## **Re. State Significant Development 5602**

### **Objection to proposed Angus Place Colliery Longwall Mine Extension Project, Newnes Plateau, NSW, by Centennial Angus Place Pty Ltd.**

Hydrographs of East Wolgan Swamp piezometers WE1 and WE2, presented with the timing of mine water discharge and longwall mining as well as the cumulative rainfall deviation trend show strong correlations between groundwater levels and mine water discharges prior to mining. Following the

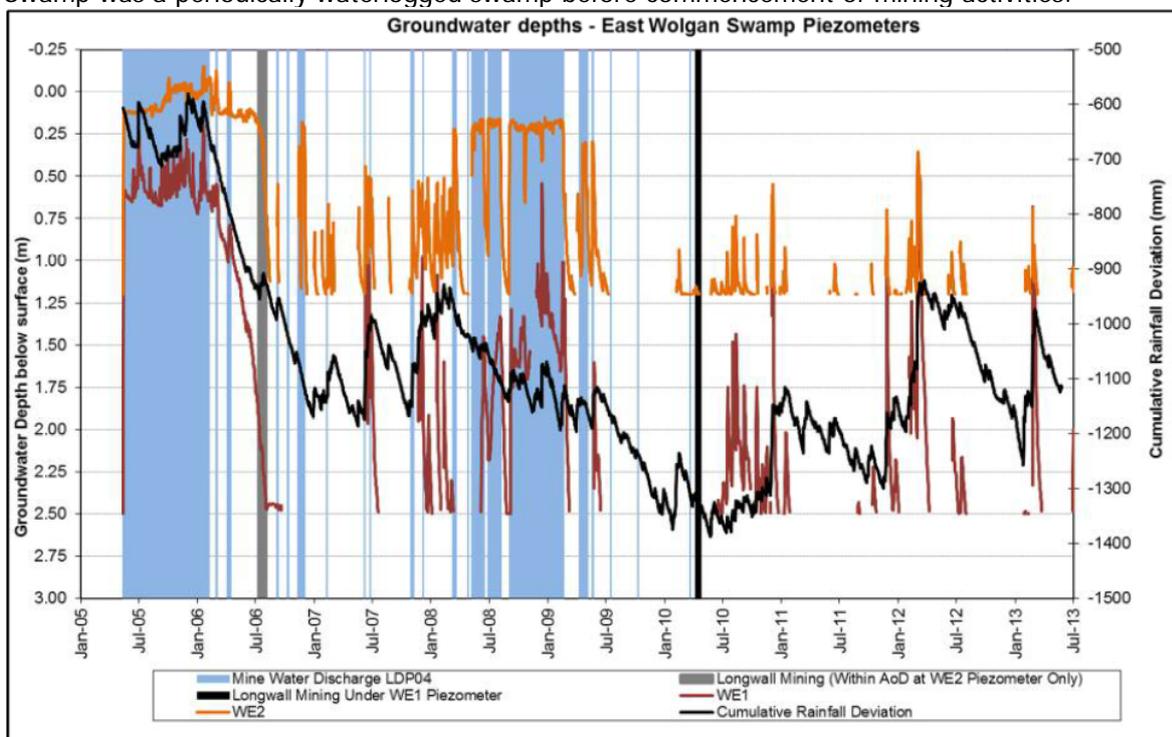
p.vi: the consultant claims that there has been no significant damage to shrub swamps from subsidence, although the Main Report clearly identifies swamps significantly affected by mine subsidence, in addition to mine water discharge, e.g. East Wolgan Swamp.

p.94: Incorrectly states that since 2005 there has been no loss of EECs or populations of threatened species. This ignores East Wolgan Swamp, where subsidence is identified as a contributing factor to the damage to this NPSS, in addition to mine water discharge. To state that “the minor alterations to
